U-17-002

APPROVAL OF LOCATION WINDMILL MESA PARK

A request by Widefield School District No. 3 for an approval of location to allow for the expansion of an existing public park. The site is located on the east side of Bradley Road, south of Marabou Way. (Parcel No. 65121-00-012) (Commissioner District No. 4) (Nina Ruiz)

1 West Parking Lot - Layout Plan

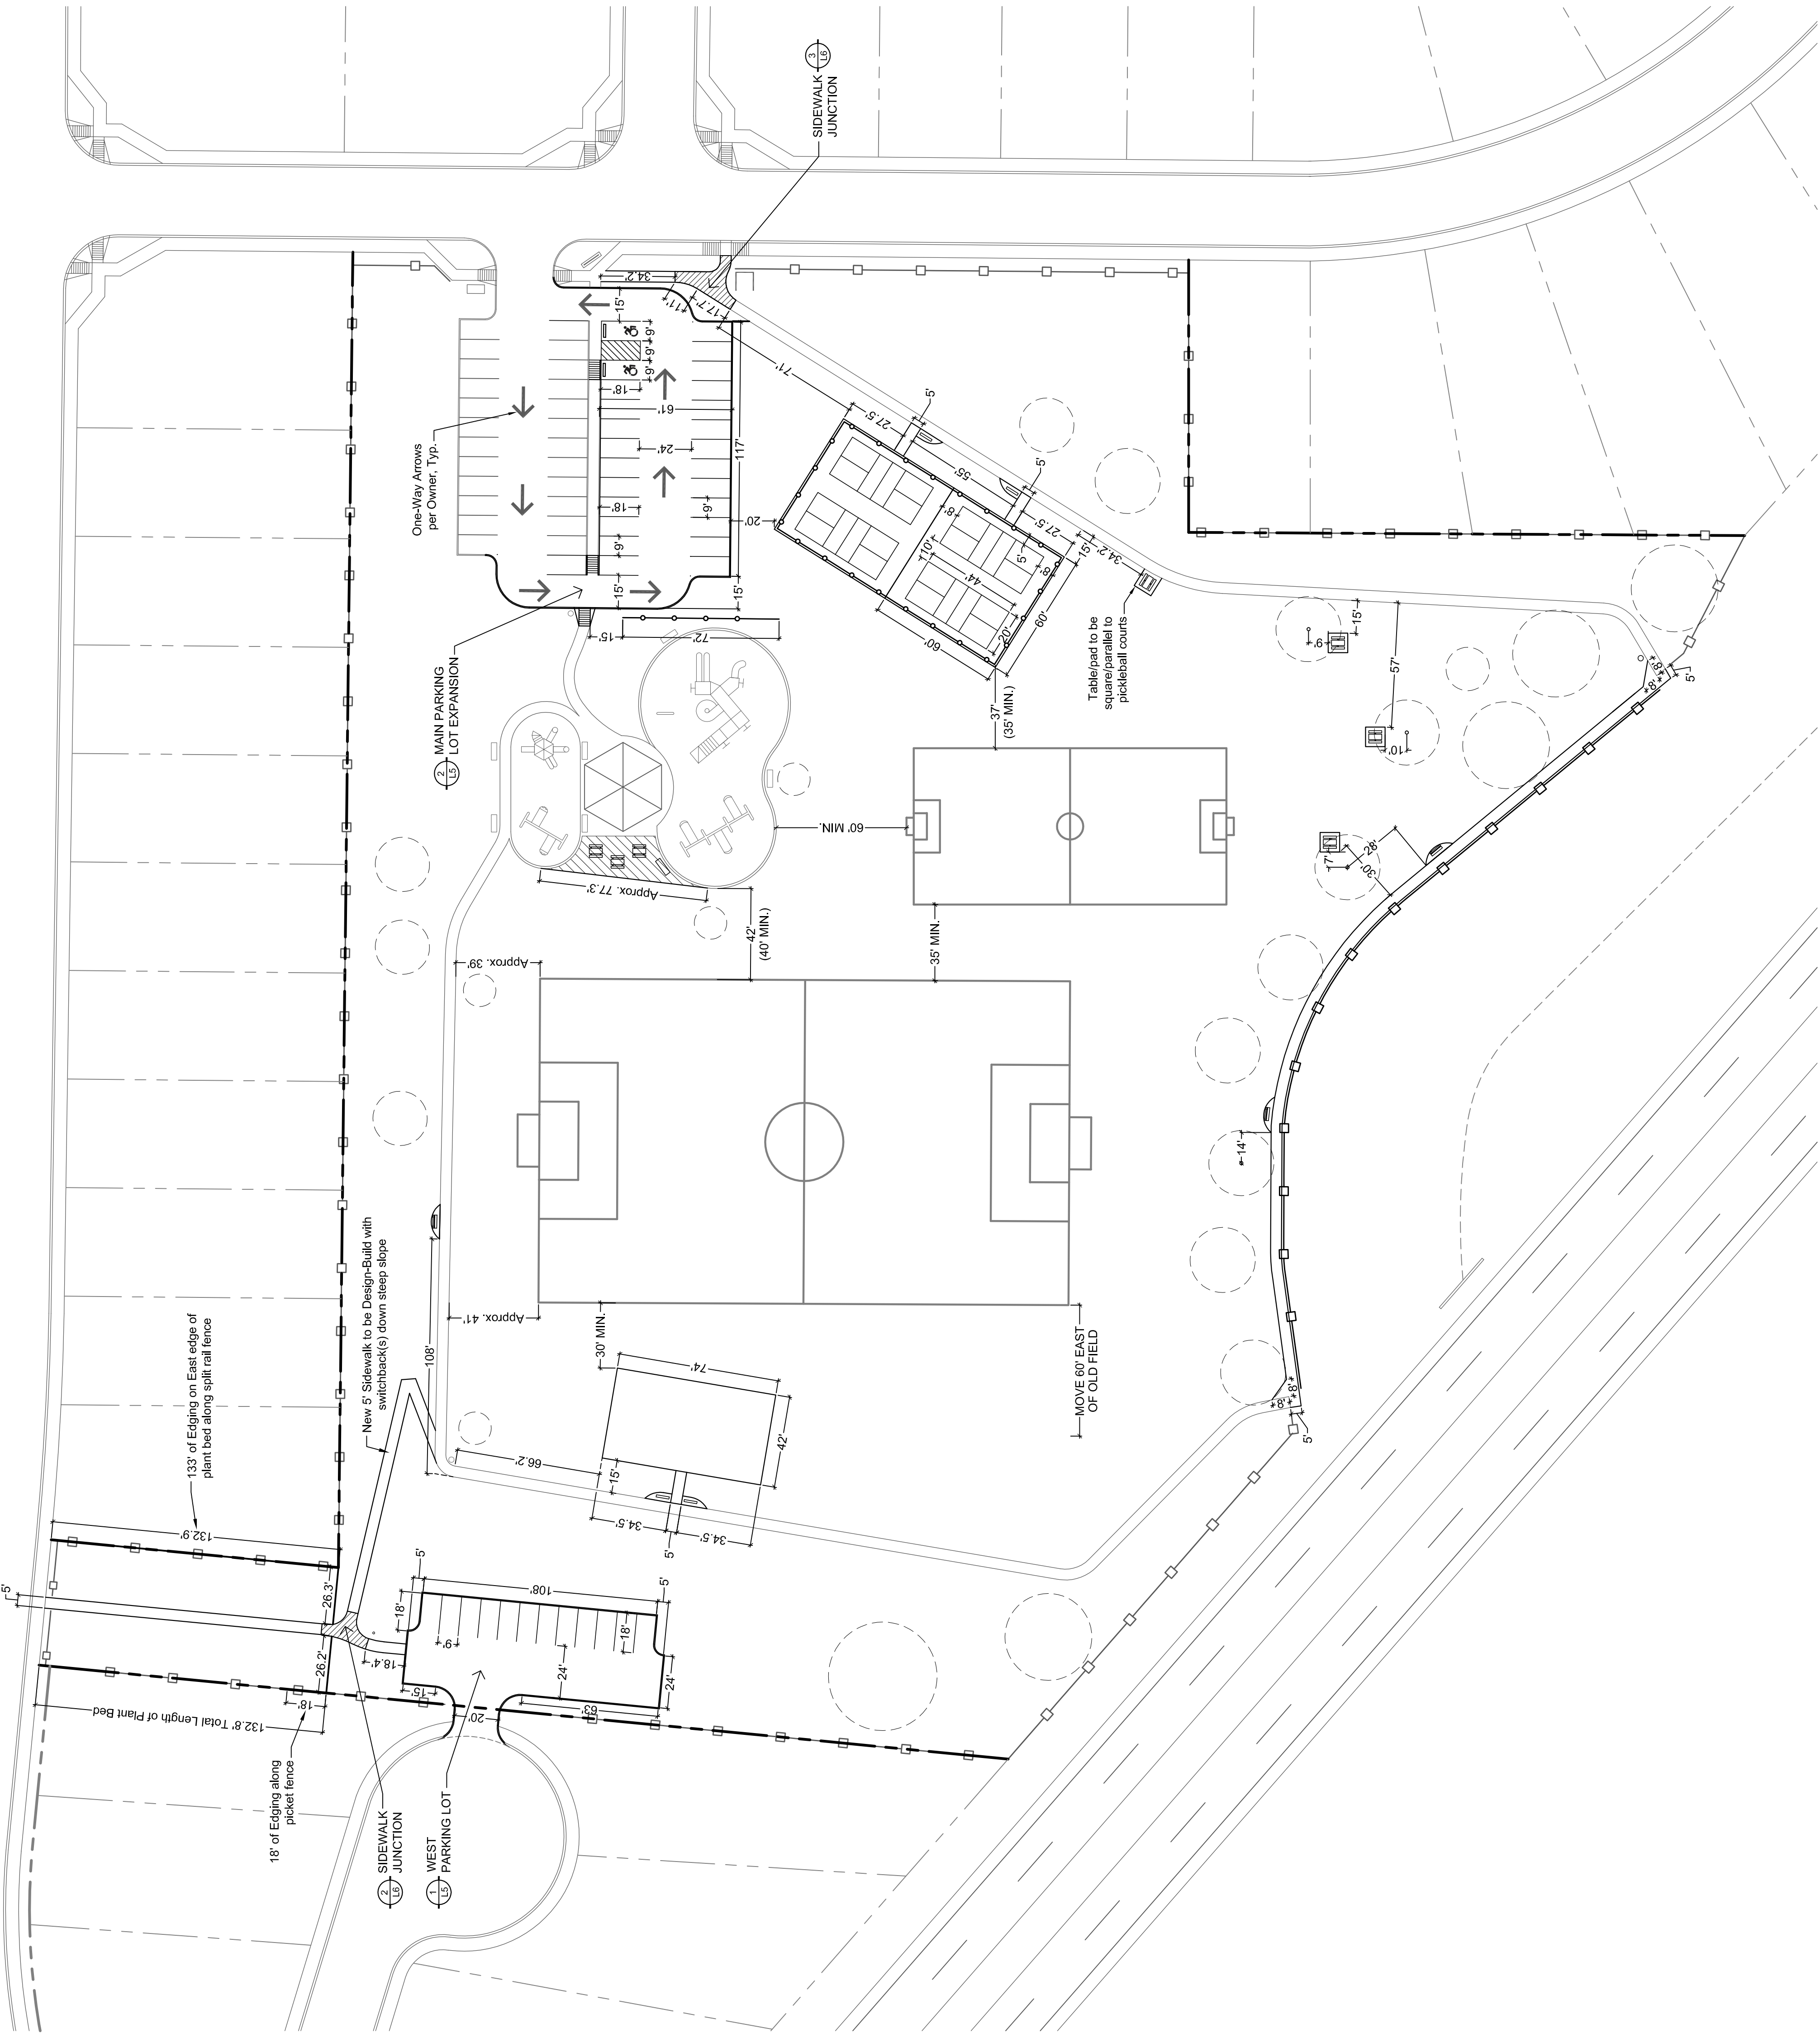
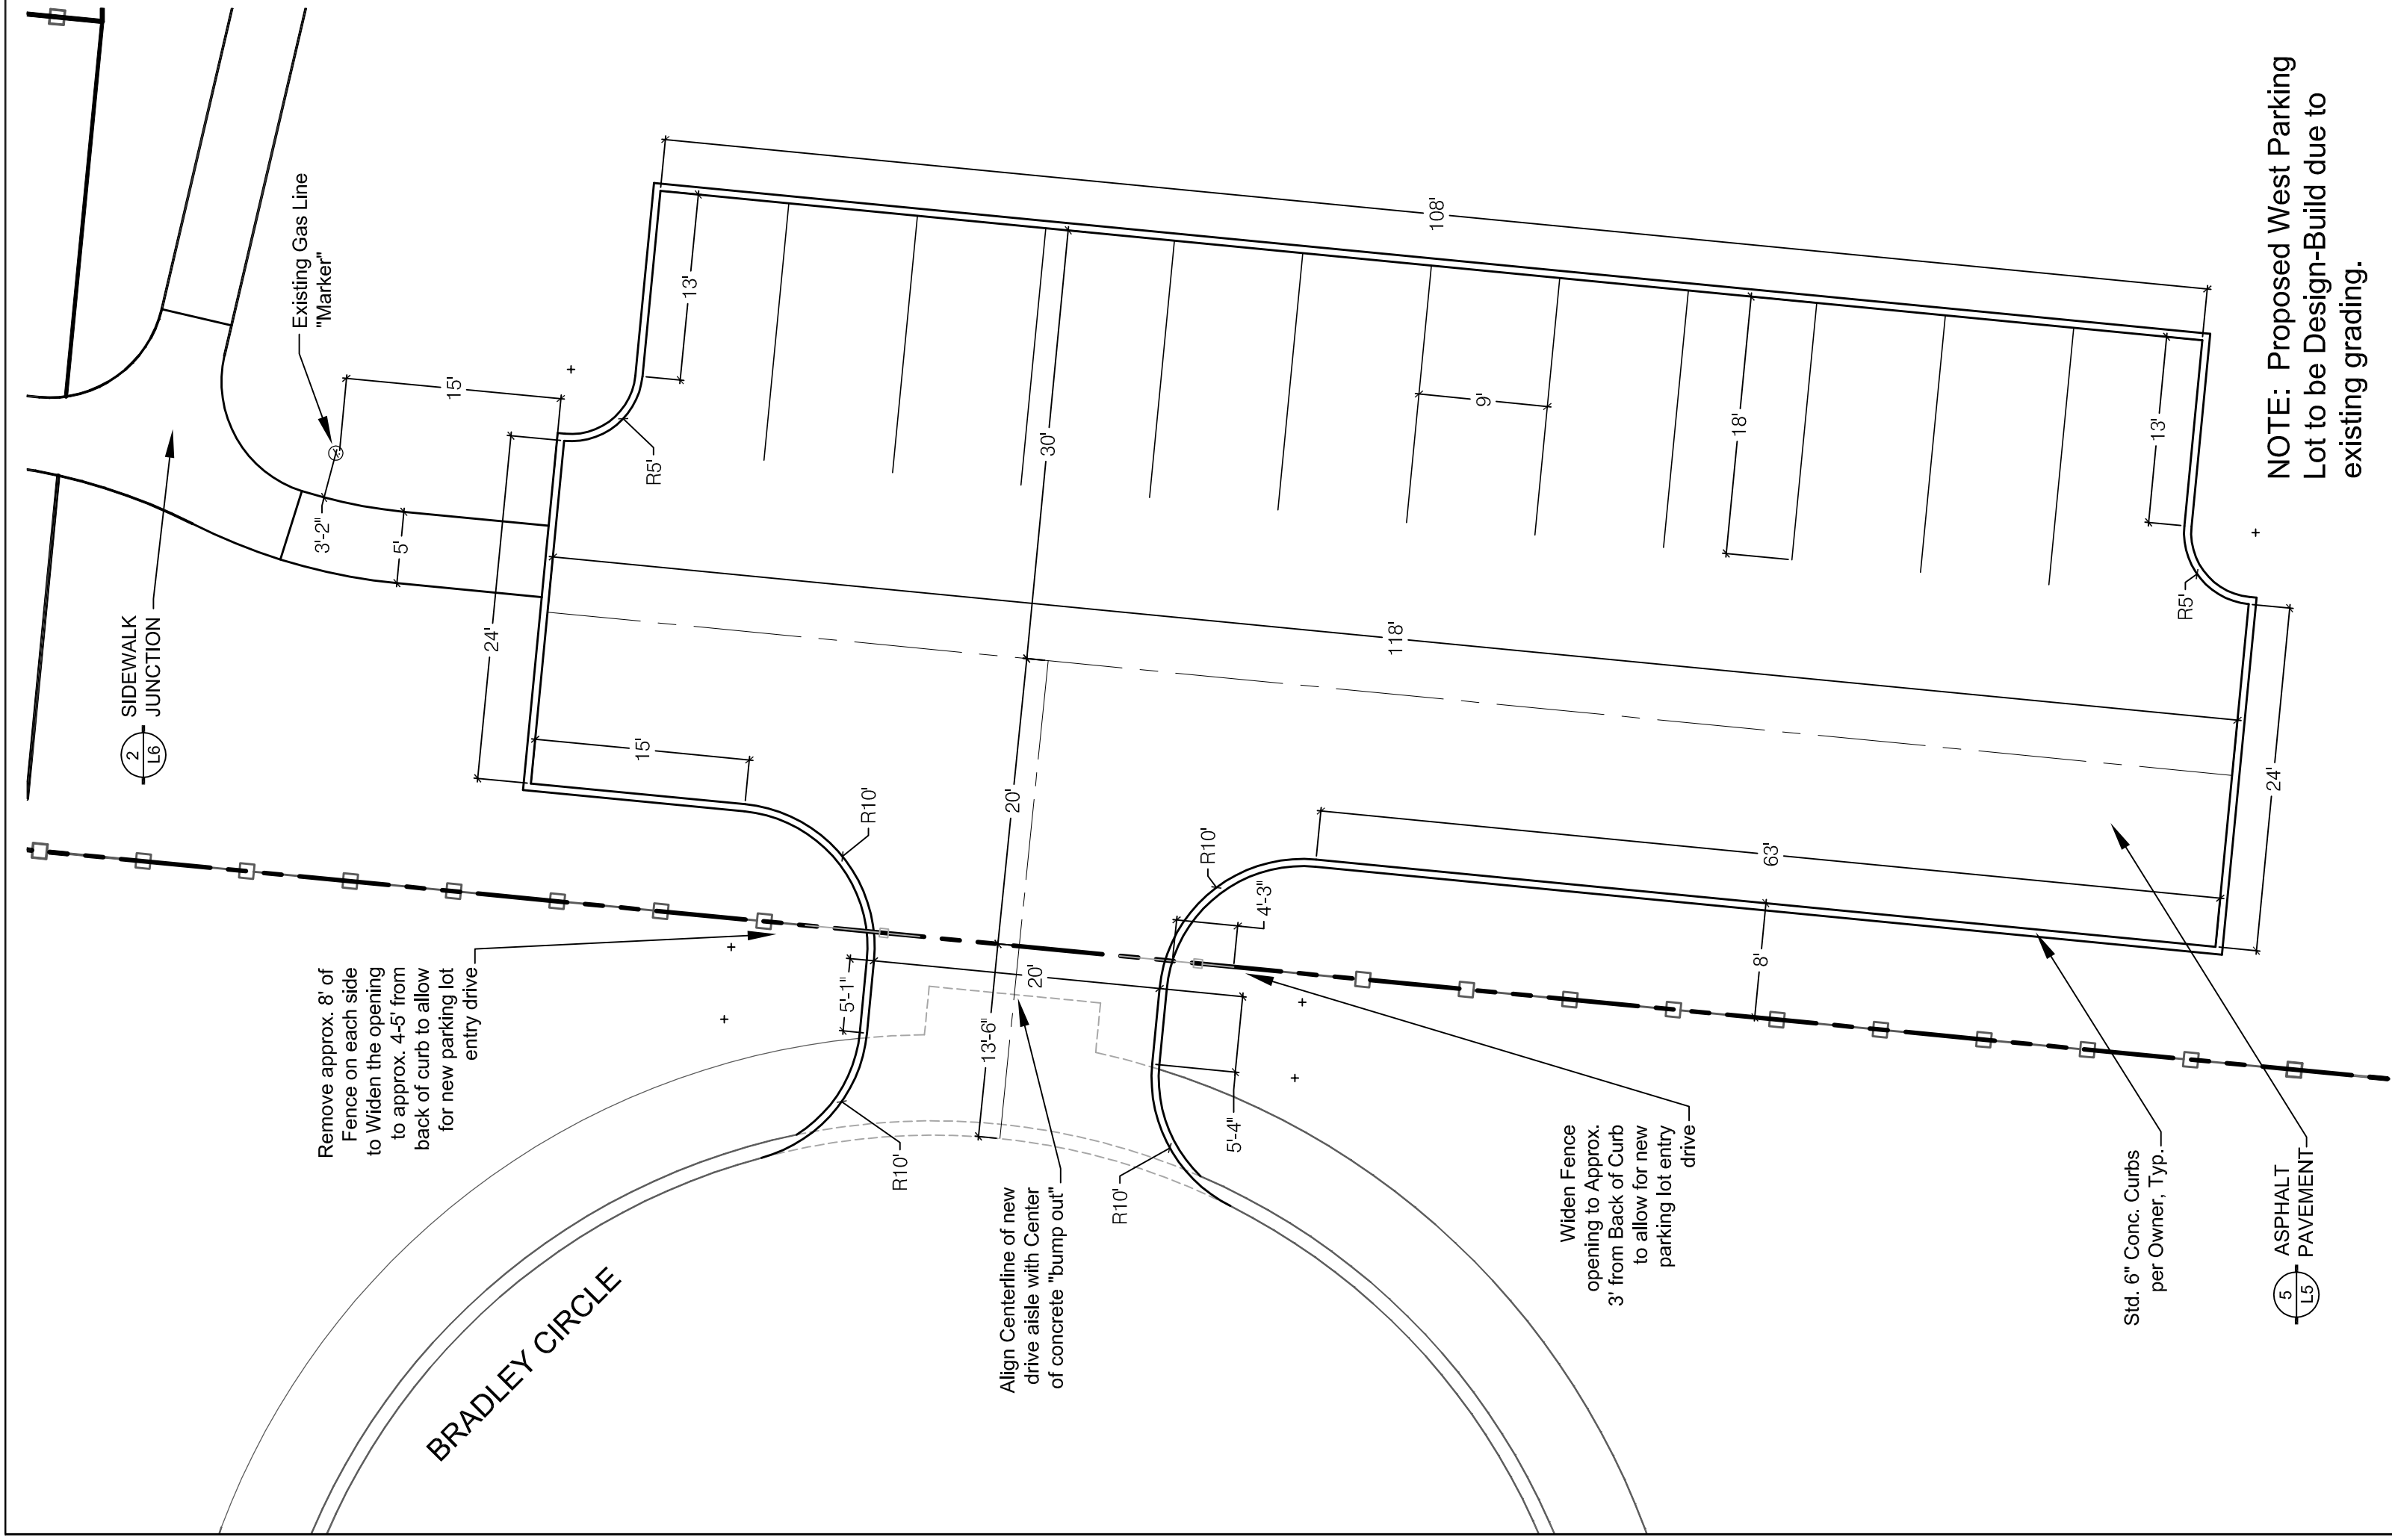
Comments: THE PROPOSED WESTERN PARKING LOT AND ACCESS ROAD DIRECTLY AFFECTS THE SAFETY AND VALUE OF TWO HOUSES I OWN ON BRADLEY CIRCLE, ONE OF WHICH HAS A PROPERTY BORDER WITH THE PARK. THE PROPOSED PARKING LOT AND ACCESS ROAD WILL GREATLY EFFECT THE PROPERTY
(FOR ADDITIONAL COMMENTS, PLEASE ATTACH ANOTHER SHEET.)
